File Number: SSD 7610  
Our Ref: R/2016/15/A

### Development Application for the Inner Sydney High School (SSD 7610)

## ATTACHMENT A

Existing Overshadowing Study 21 June

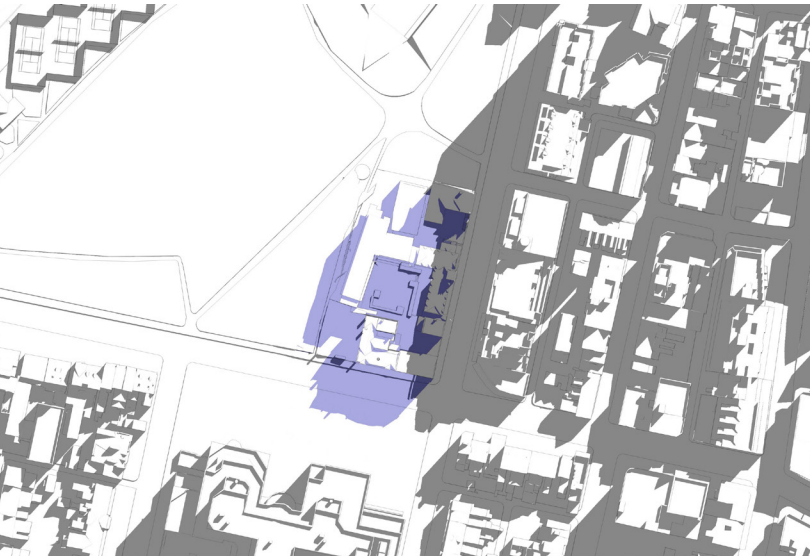
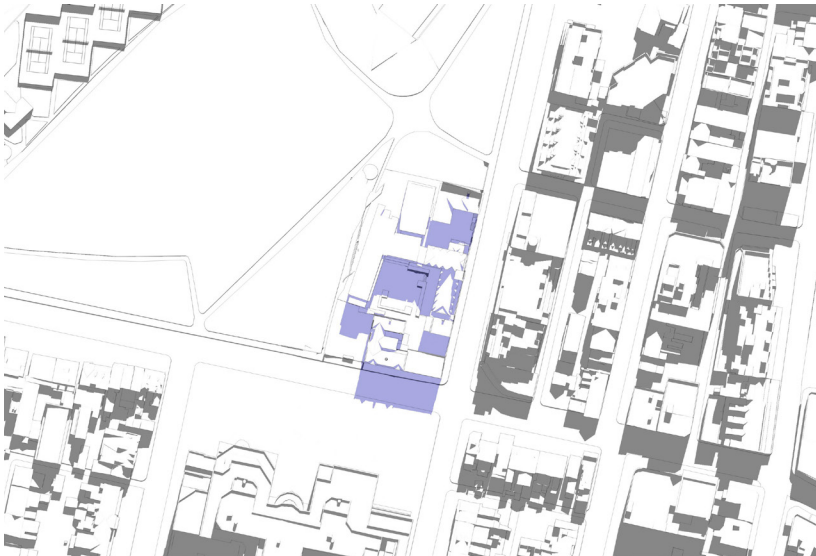
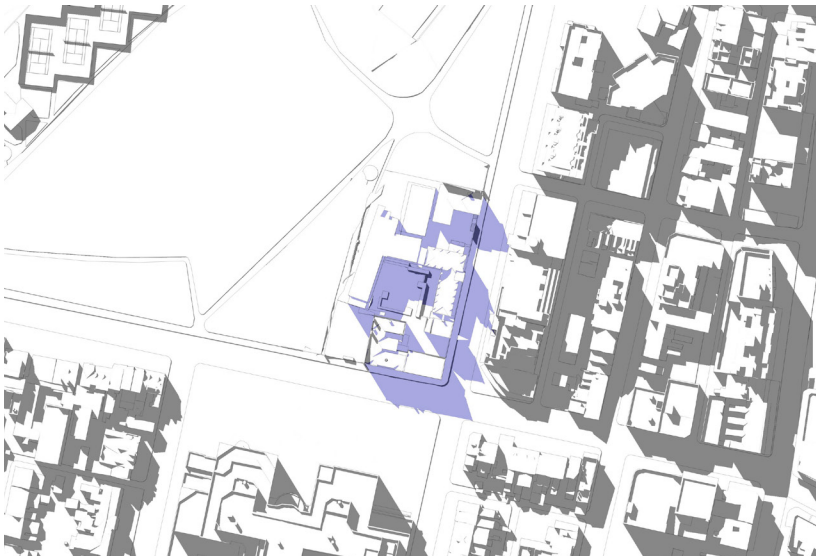
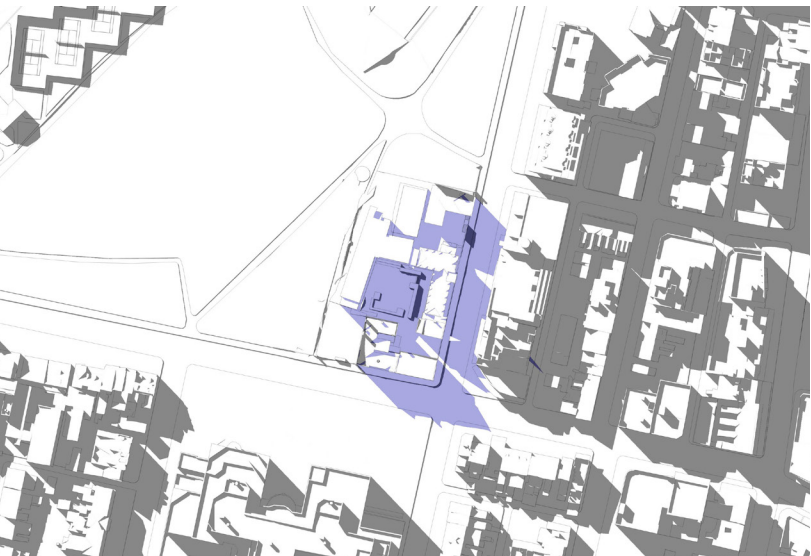
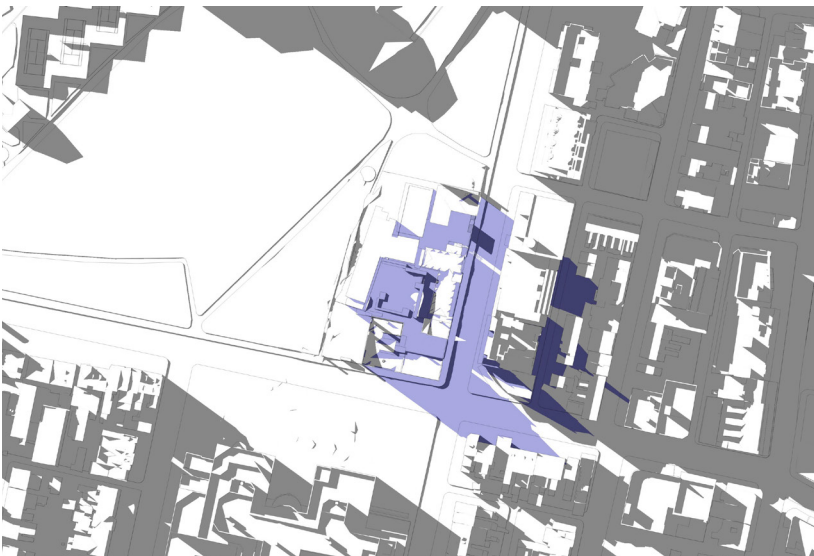
- There is a discrepancy in the material provided in relation to the shadows cast by the proposal. The *Shadow Impact Analysis* drawing on page 18 of the Architectural Design Statement (ADS) does not match the shadows shown on page 19. The City has had to assume that the analysis diagram would show 21 June.

- The following is the City's analysis of both diagrams shown on pages 18 and 19, which are of interest:
  - o The proposal creates a minor shadow to Prince Alfred Park between 9-11am.

- o Larger properties located to the east of the site which have west facing openings will be impacted by the proposal. These properties rely on solar access from 1-3pm (we have discounted the midday sun angle as it is too oblique to the facade to be of any substantial effect.) These properties include:

- 204-214 Chalmers Street (impacts to 12 apartments facing west onto Chalmers Street and communal roof terrace)
    - 188 Chalmers Street (potential impacts to those apartments located to the south of the Chalmers Street facade at 3pm).

- The plan view shadow diagrams do not provide sufficient detail to quantify the impact to 204-214 and 188 Chalmers Street.
- In consideration of the above, clarification should be provided as to which diagram is accurate for 21 June and this information placed on public exhibition for comment.

- To complete the assessment, additional material, in the form of detail views from the sun should be provided for the west facing apartments in both 204-214 and 188 Chalmers Street. Each apartment must be counted individually and the analysis should provide both existing and proposed hours of solar access to living room windows, private and communal open space.
